Ribble Valley Borough Council
Housing & Development Control

Application no: **3/2020/0187**

Address: **Rockhaven Ribchester Road Clayton le Dale BB1 9EG**

Proposal: **Alterations to a detached bungalow including two extensions to the front, an altered roof pitch and a detached garage with new front boundary gates and a new stone wall**

Title
**Proposed site layout plan and Garage
 Entrance details**

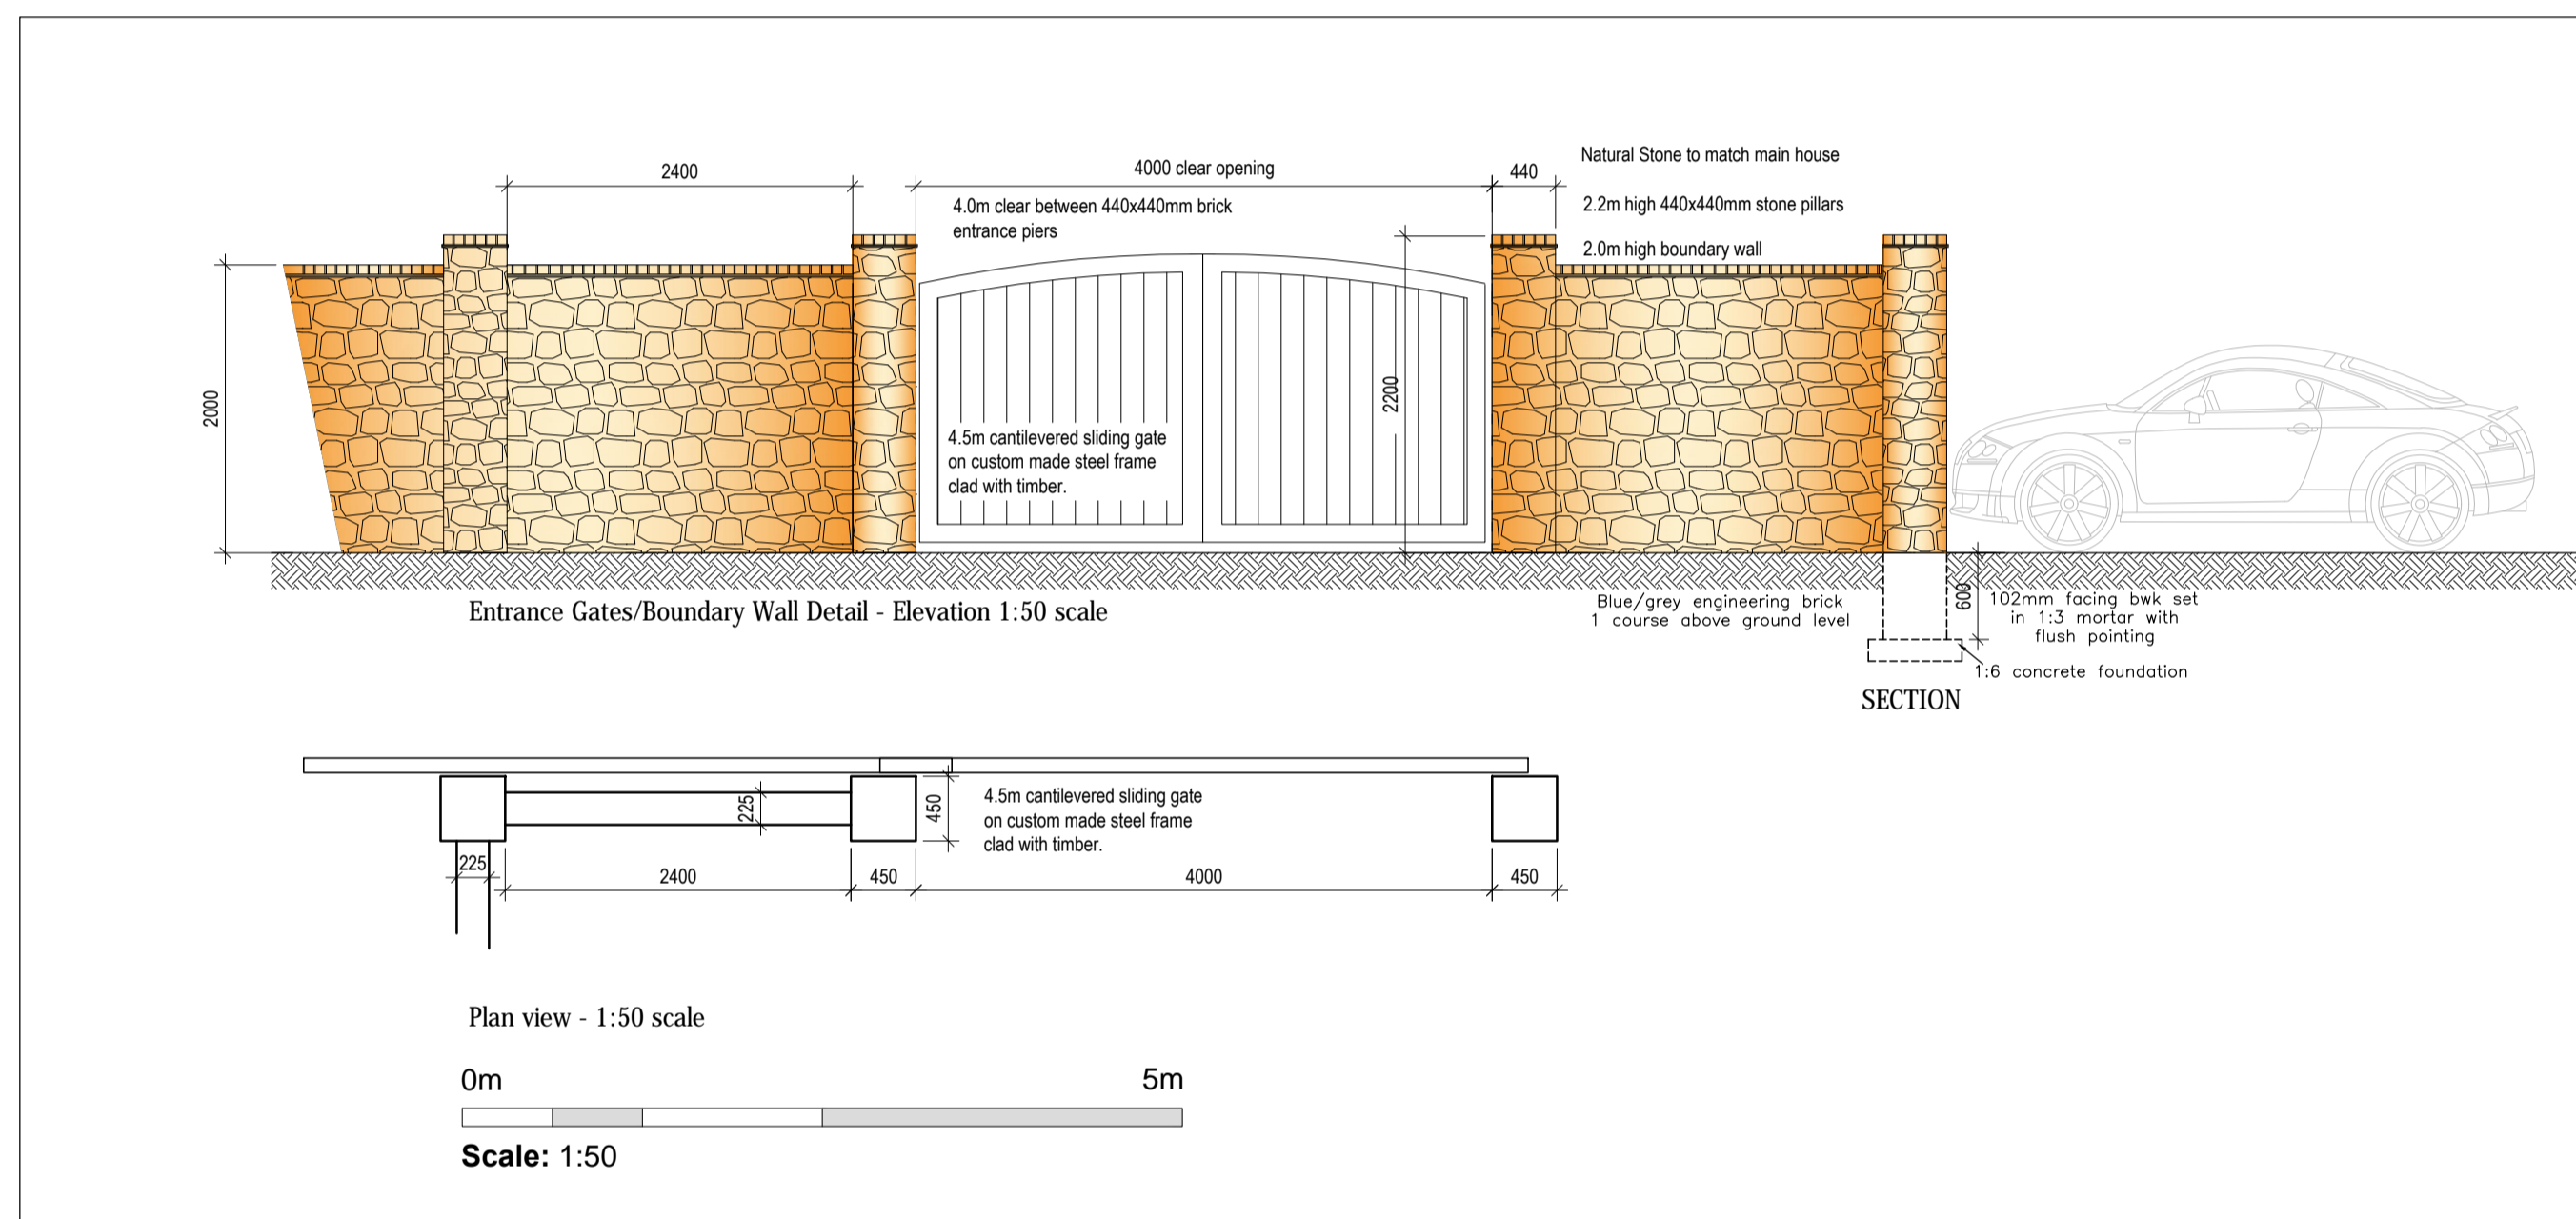
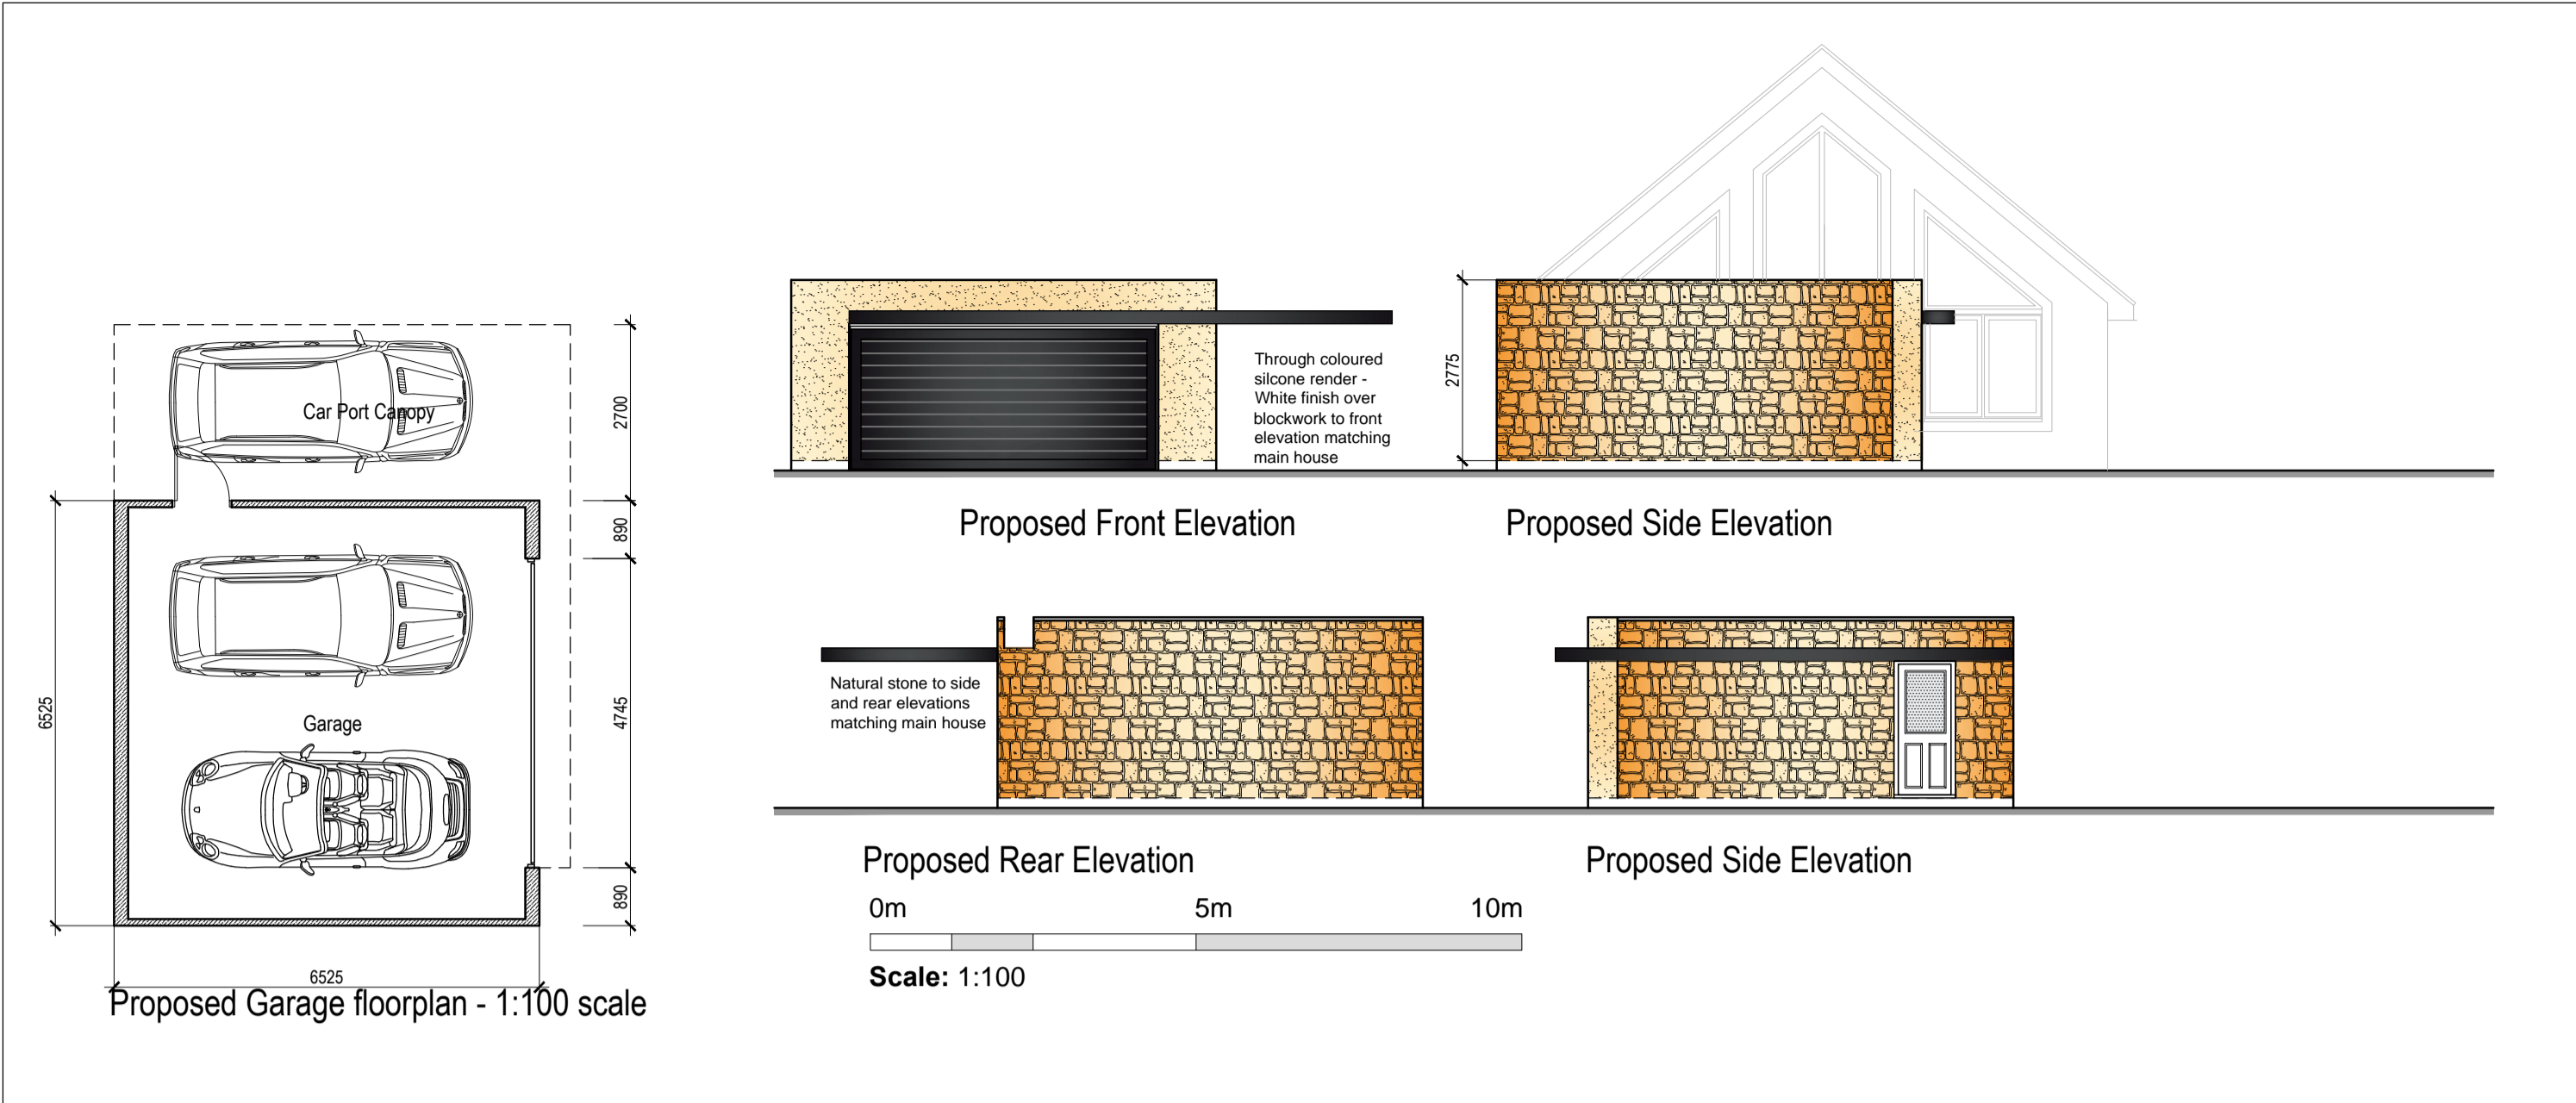
The amended drawing demonstrates the proposed access arrangements in a more clearly defined format and subject to the boundary wall being set back 2.5m from the carriageway as stated within the proposed layout and that visibility splays at the access point including the visibility splays of neighbouring properties where these cross the applicants ownership boundary remain clear and free from obstruction in perpetuity of the development proposal, then the proposal would raise no highway concerns. However, the construction of the new access point shall be carried out under a legal agreement between the applicants and Lancashire County Council under Section 278 of the Highways Act 1980 and therefore if planning approval is granted, then the

1. Notwithstanding the provisions of the Town and Country Planning (General Permitted Development) Order 1995 there shall not at any time in connection with the development hereby permitted be erected or planted or allowed to remain upon the land hereinafter defined any building, wall, fence, hedges, trees, shrubs or other devices over 1.05m above road level. **Reason:** To ensure adequate visibility at the street junction or site access.
